**DELEGATED DECISION FOR APPLICATION FOR CERTIFICATE OF
LAWFUL DEVELOPMENT**

Reference no.: 2023/CL/92206/W

Site: 23, Roundway, Honley, Holmfirth, HD9 6BU

Description: Certificate of lawfulness for proposed erection of garage, alteration of window to door, removal of store and dropped kerb

DATE: 04.07.23 DRAWN: AHD  
SCALE: 1:50,100, 1:250 CHECKED: ANK  
SIZE: A1 DRG NO: 23.2732.03A

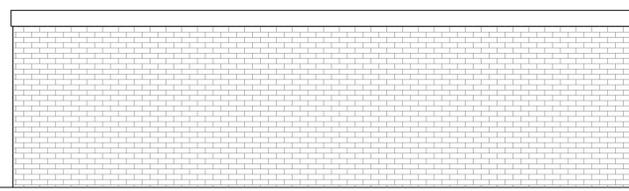
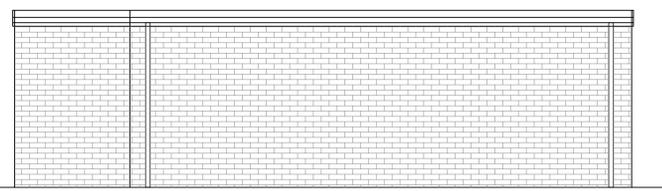
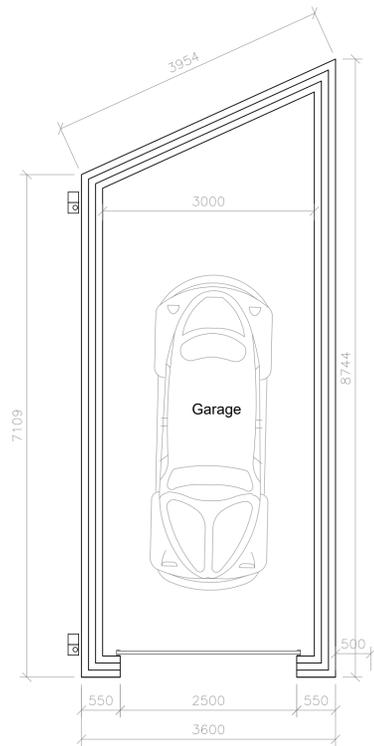
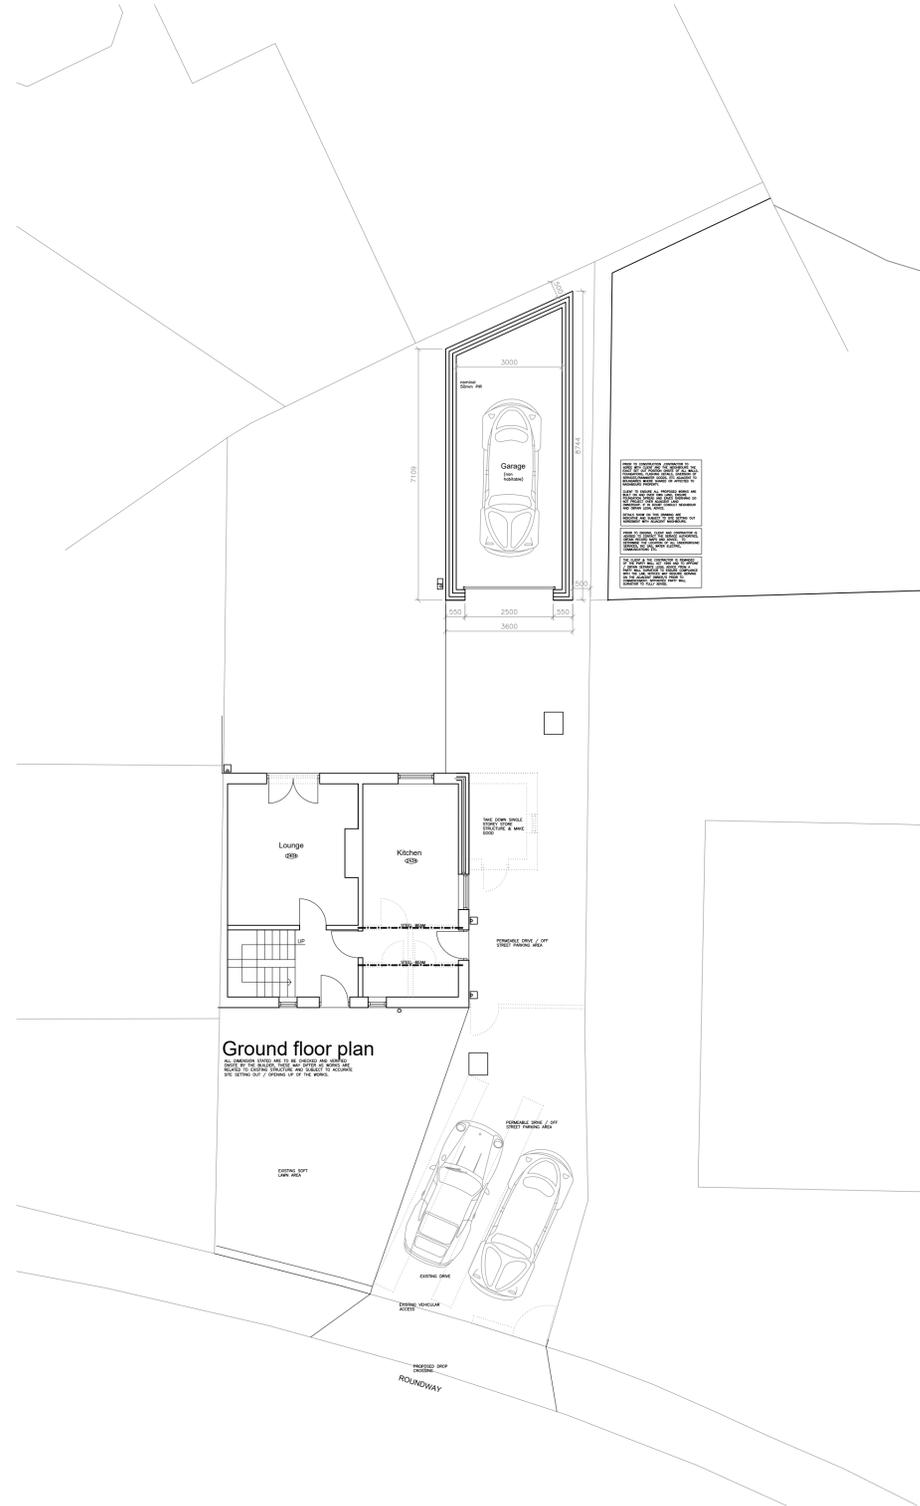
Length: 8.75 metres in length.

Width: 3.6 metres in width.

Height: 2.5 metres in height.

The proposed outbuilding would be constructed from red brick to match the host dwelling and would be slanted roof in nature. A store would be removed to allow access to the outbuilding. A window would be replaced by a door on the rear elevation.

Comment: *The proposed outbuilding would not project beyond the principal elevation (that which contains the main entrance door and architectural detailing).*

Comment: *The proposed outbuilding would be single storey.*

Comment: *The proposal would be located within 2.0m of the boundary of the curtilage and has a maximum height of 2.5 metres.*

Comment: *The proposed eaves height of the outbuilding would not exceed 2.5m*

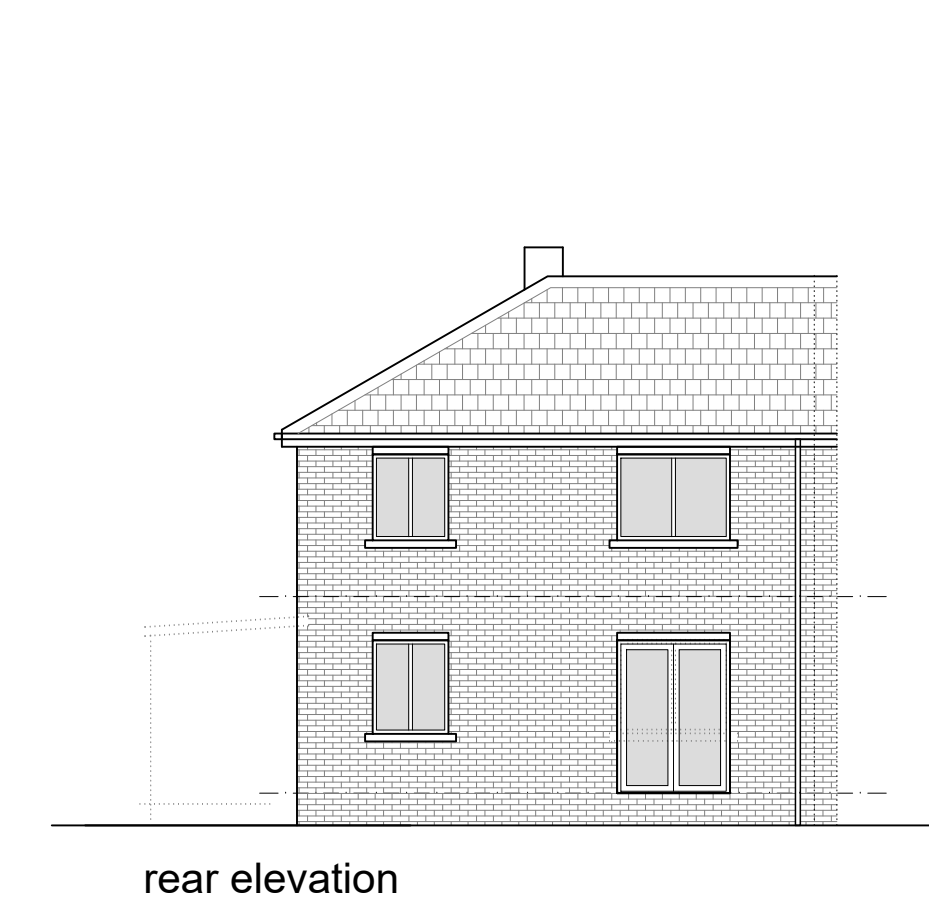
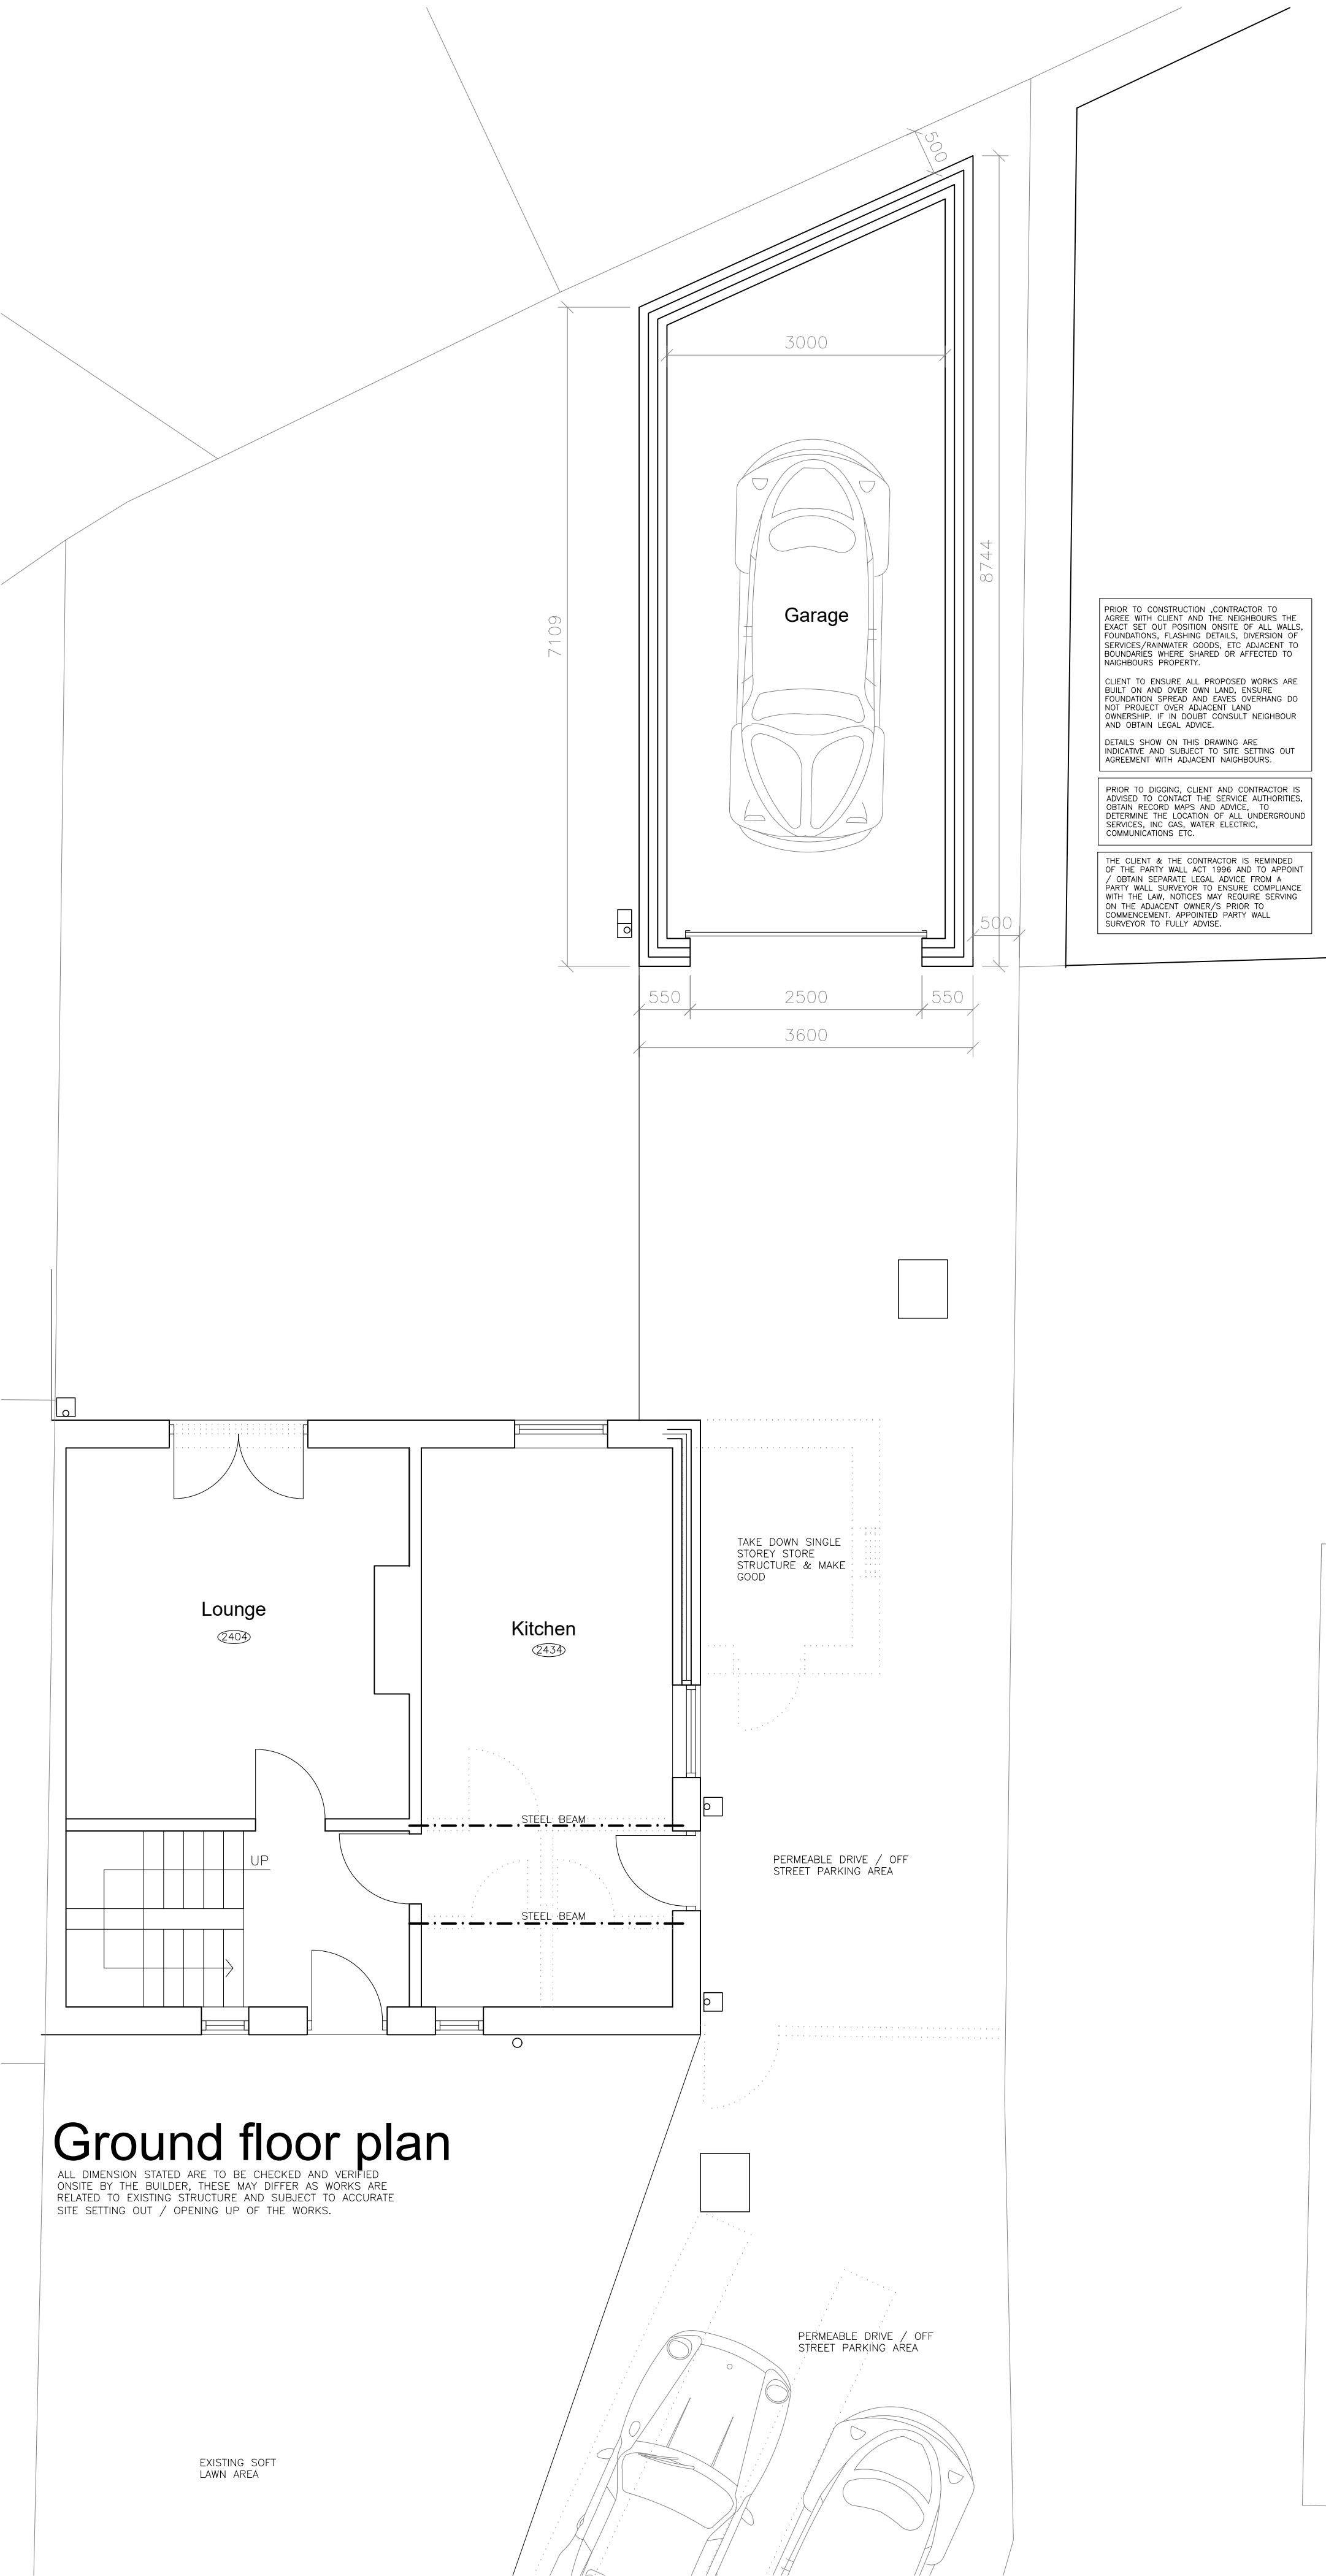
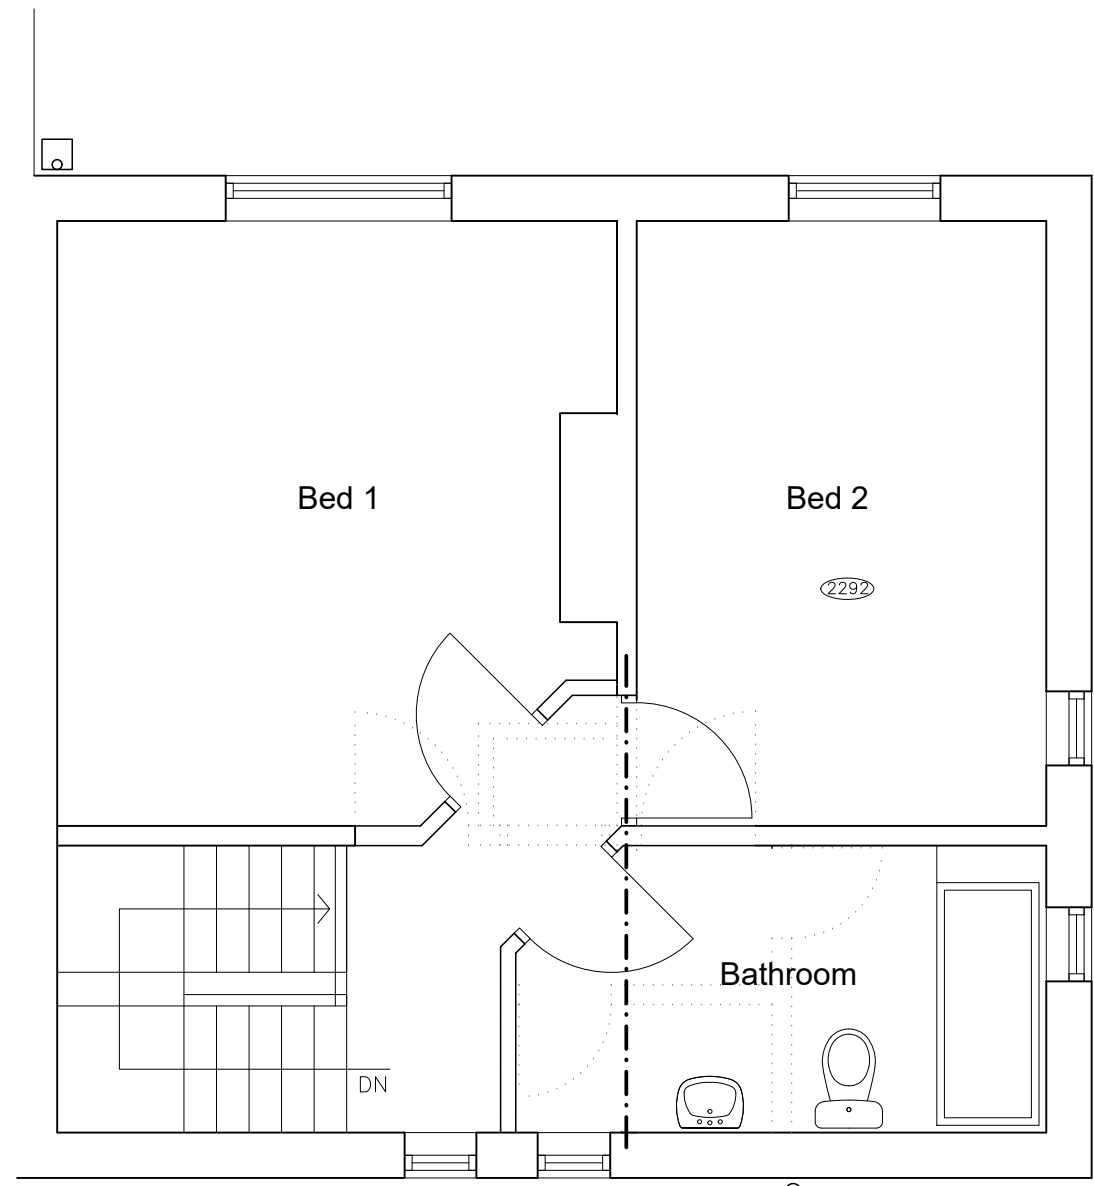
Removal of store and alterations of rear window to French doors
